26 July 2022

**Temple Oaks Renewable Energy Park
EIA Scoping Report consultation**

Thank you for the opportunity to comment on the scoping report for the above project which is principally located at the former RAF Folkingham in South Kesteven district with the grid connection crossing into North Kesteven, South Holland and Boston in Lincolnshire.

Plate 1 - Potential Area for Solar Farm and Battery Energy Storage System (red line)

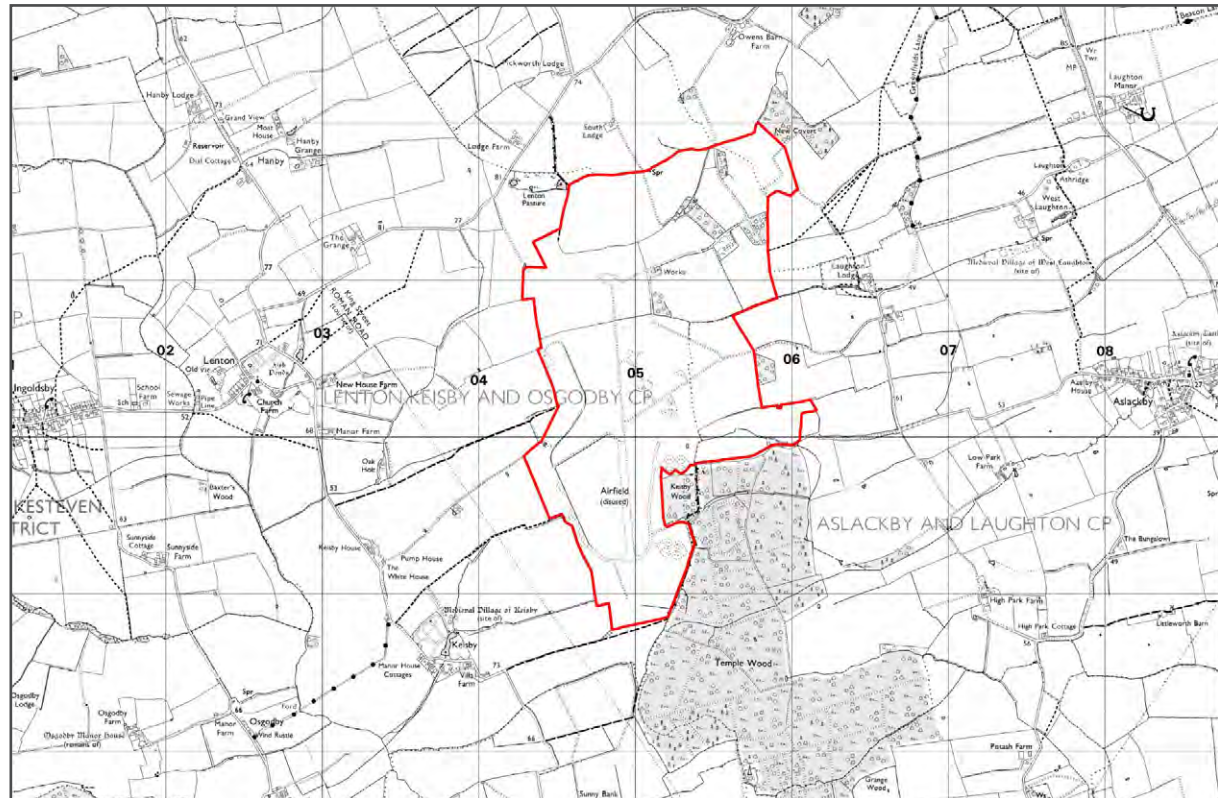
Anglian Water is the appointed water and sewerage undertaker for the site shown on plate 1 (page 3). The following response is submitted on behalf of Anglian Water in its statutory capacity and relates to potable water and public water supply assets.

Having reviewed the site area and route of the grid connections, there Anglian Water assets including water and sewer mains within and adjoining the site. These assets include water mains which cross the north east section of the main site and which, for example, serve Laughton Hall Farm and other properties. The grid connection routes which cross roads or are near to villages also potentially impact the public water supply and public sewer networks serving in the villages of Laughton, Folkingham, Threekingham, Bridge End Donington and Bicker.
